Community Services Planning Department

RESPONSE TO COMMENTS MAY 26, 2020

Reference: Aspen Ranch Preliminary Plat

DT01
 SHEET 2 OF 22
 CITY FILE NO.:

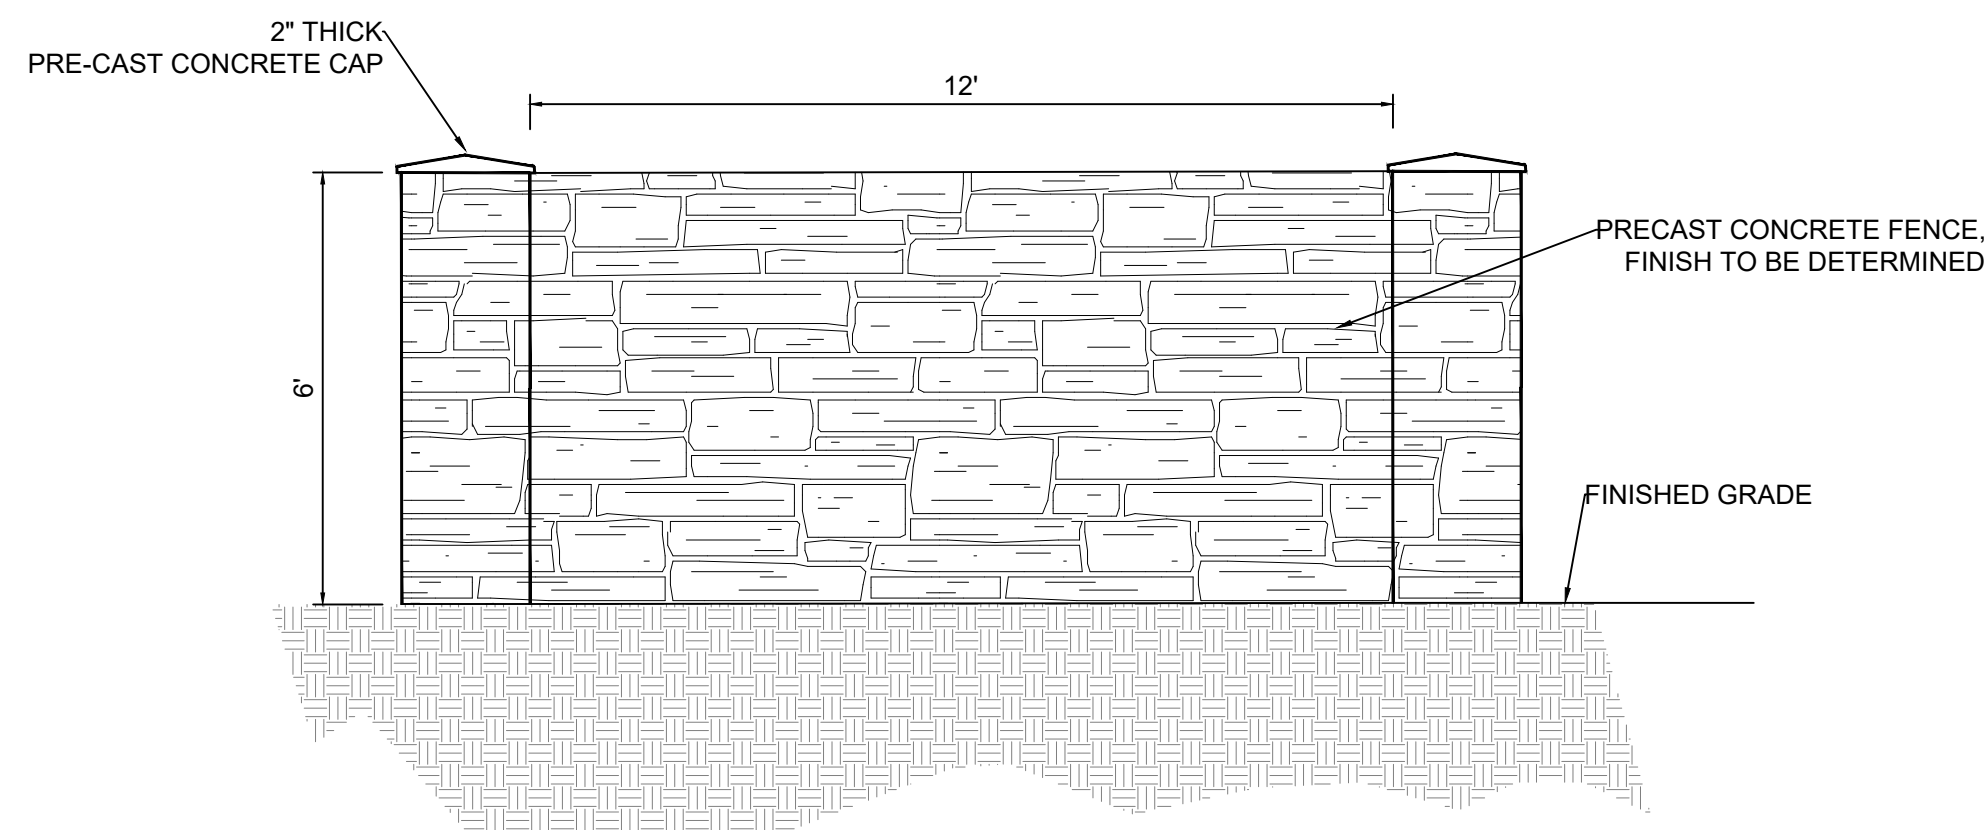
1. Tract F is planned for the Public Safety Site. Please convert this Tract to a lot. The lot will still be transferred to the City with the final plat. **ADDRESSED: TRACT HAS BEEN CONVERTED TO LOT 218.**

SHEET 4 OF 22

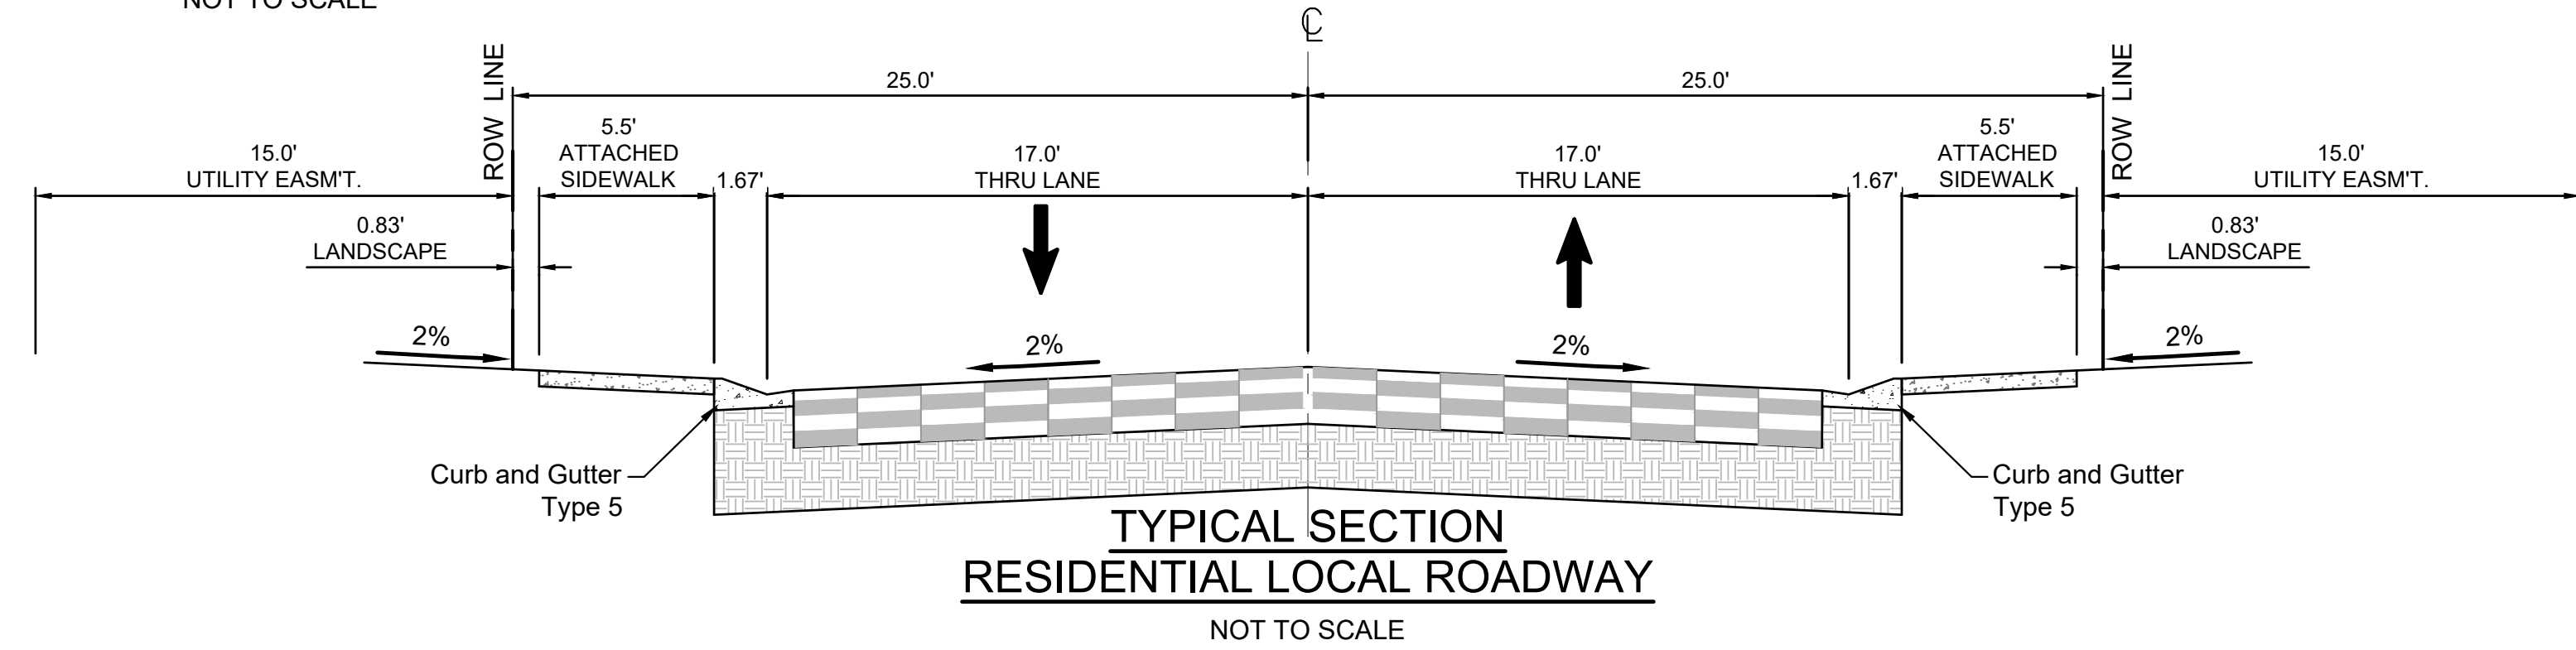
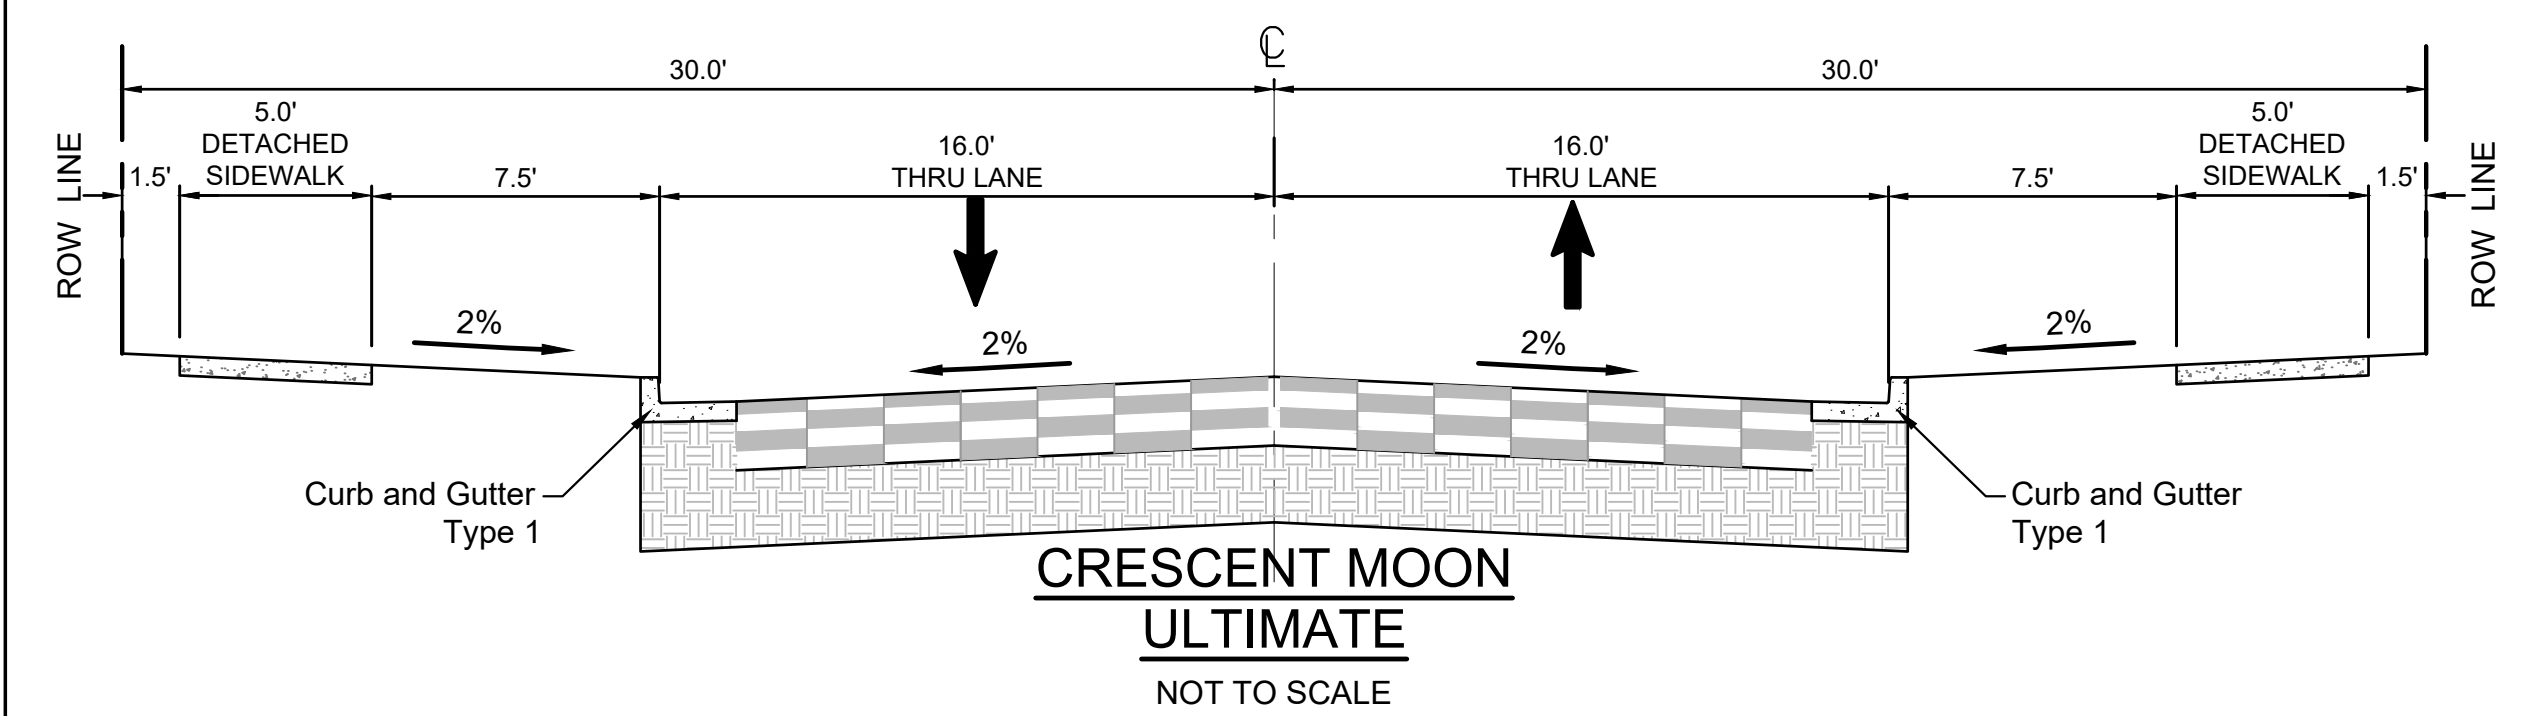
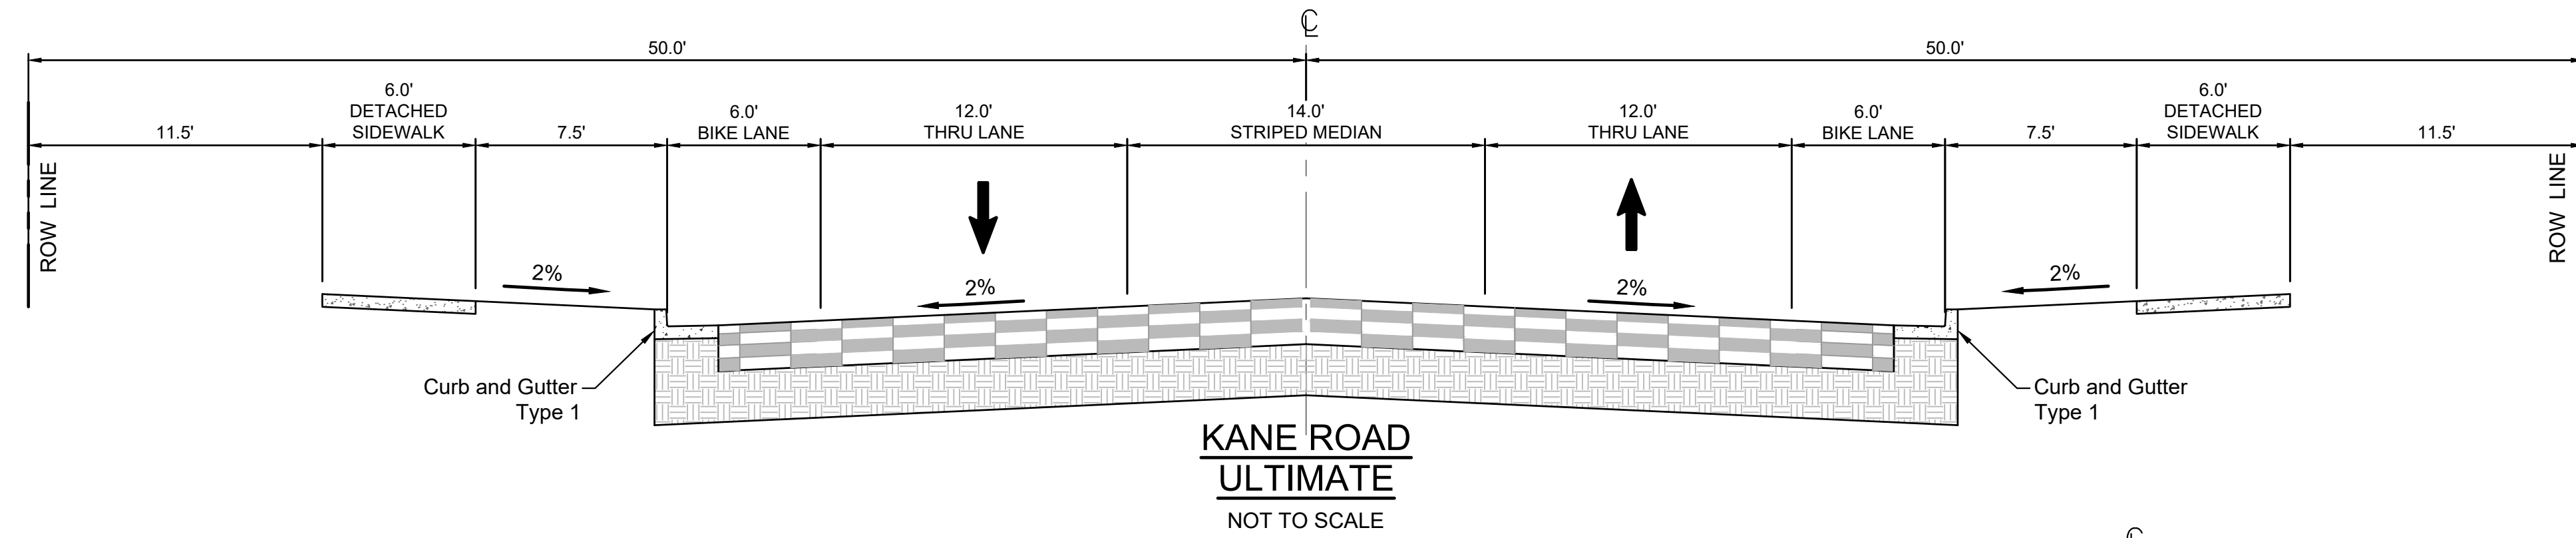
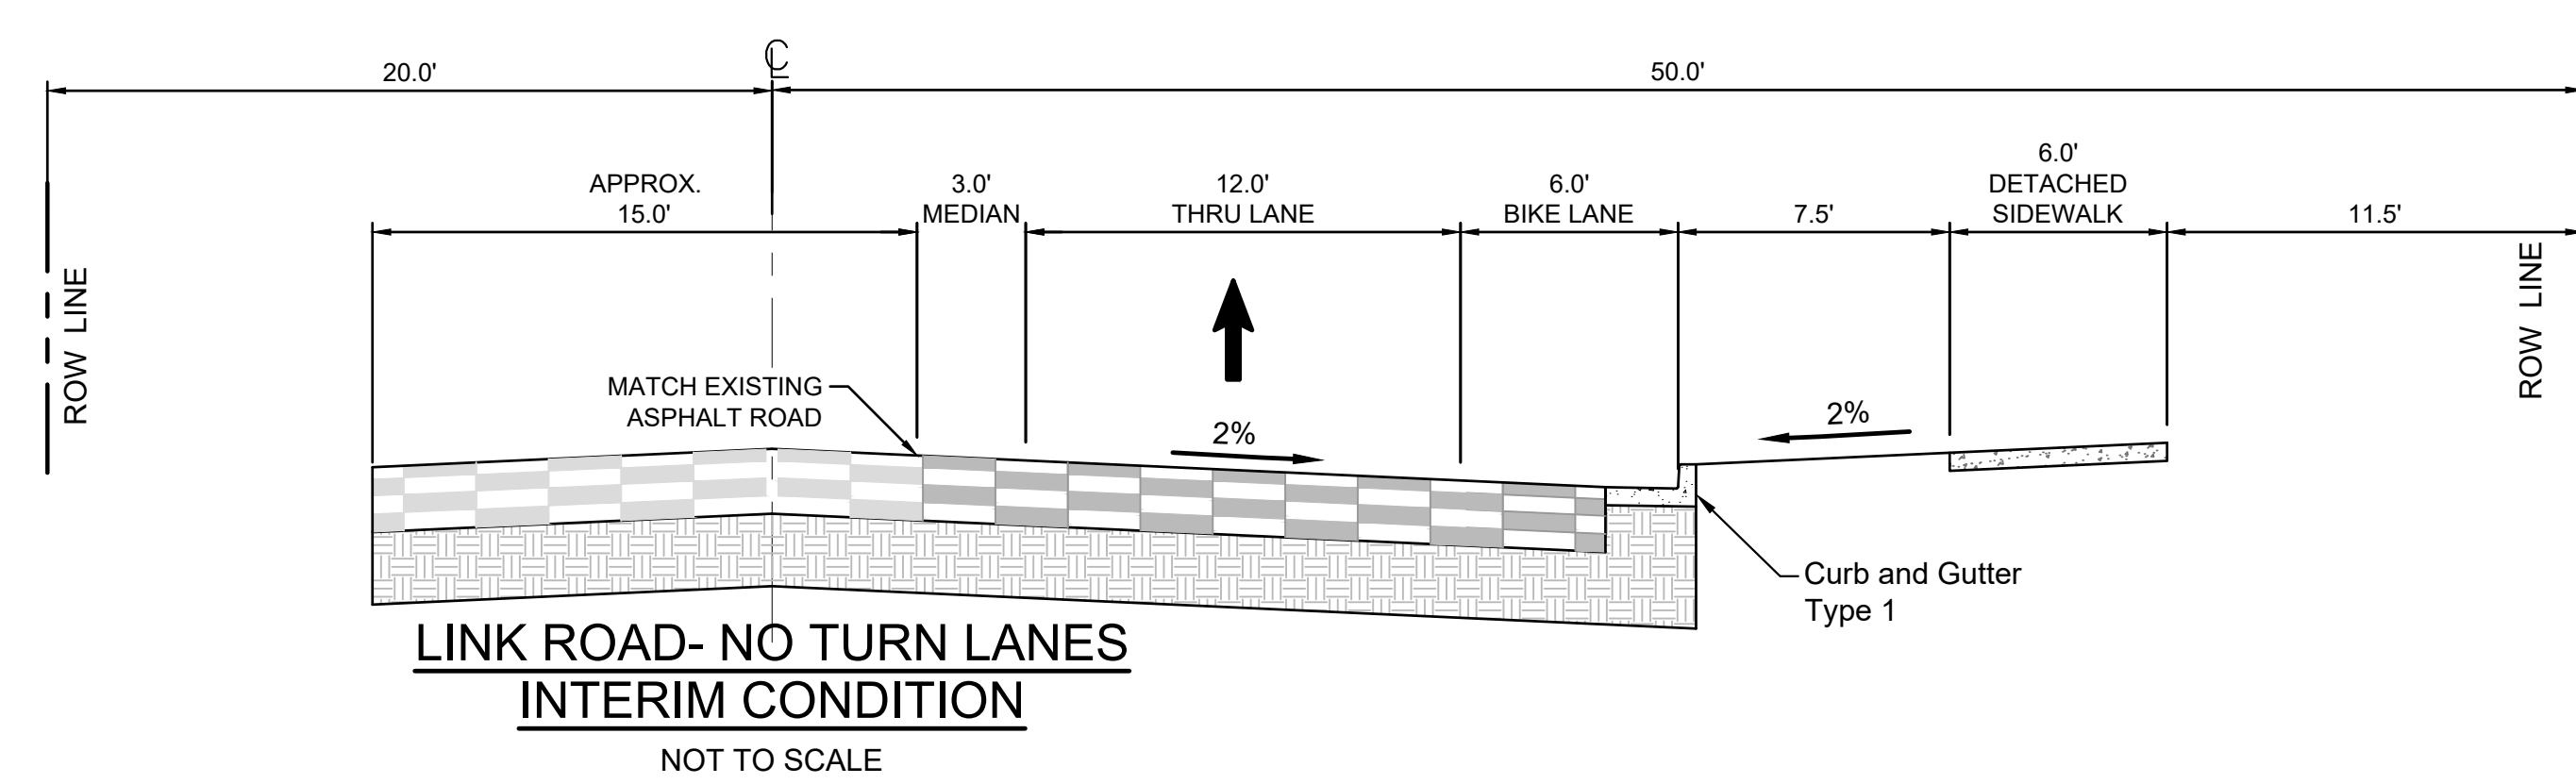
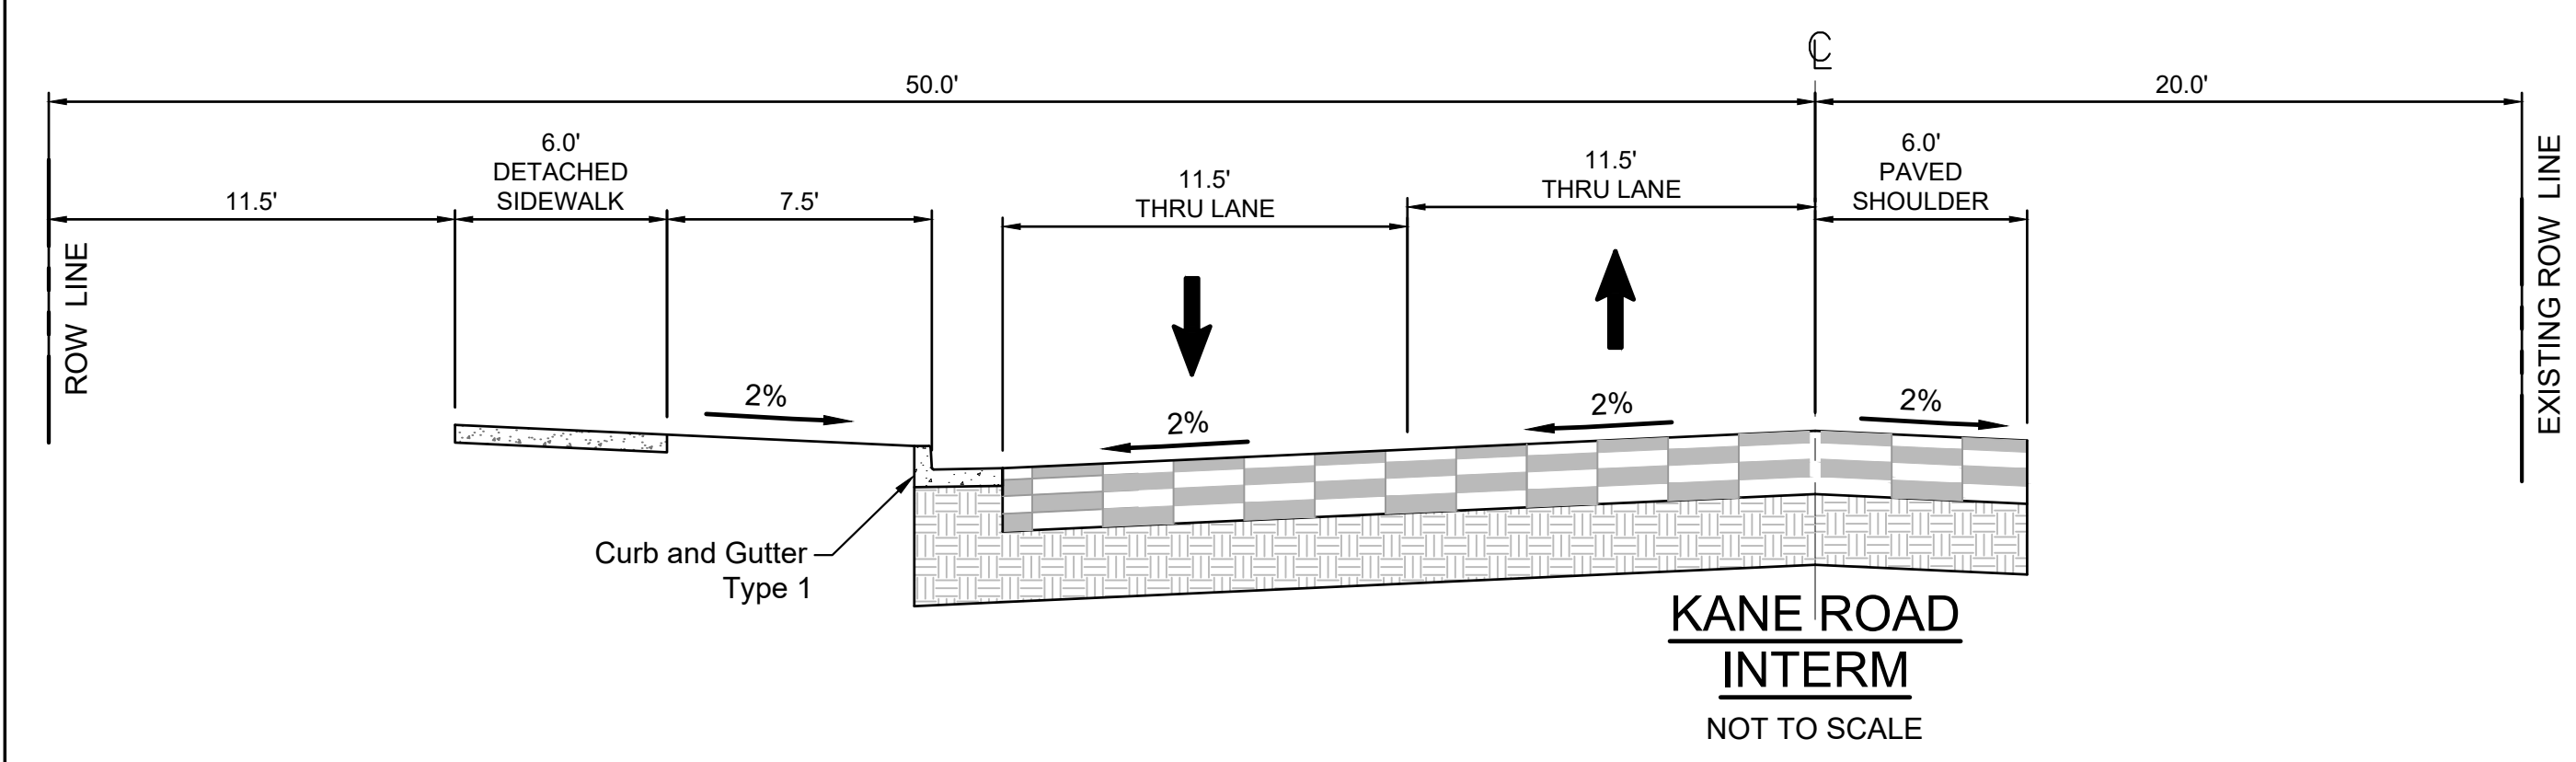
The 15' front-lot Utility Easements shown on the Residential Local Roadway Cross-section on Sheet 4 are not reflected anywhere else on the plat documents. **ADDRESSED: THE ROADWAY CROSS SECTIONS AS WELL AS GENERAL NOTE #14 ON THE COVER SHEET ILLUSTRATE THE 15' FRONT LOT EASEMENT.**
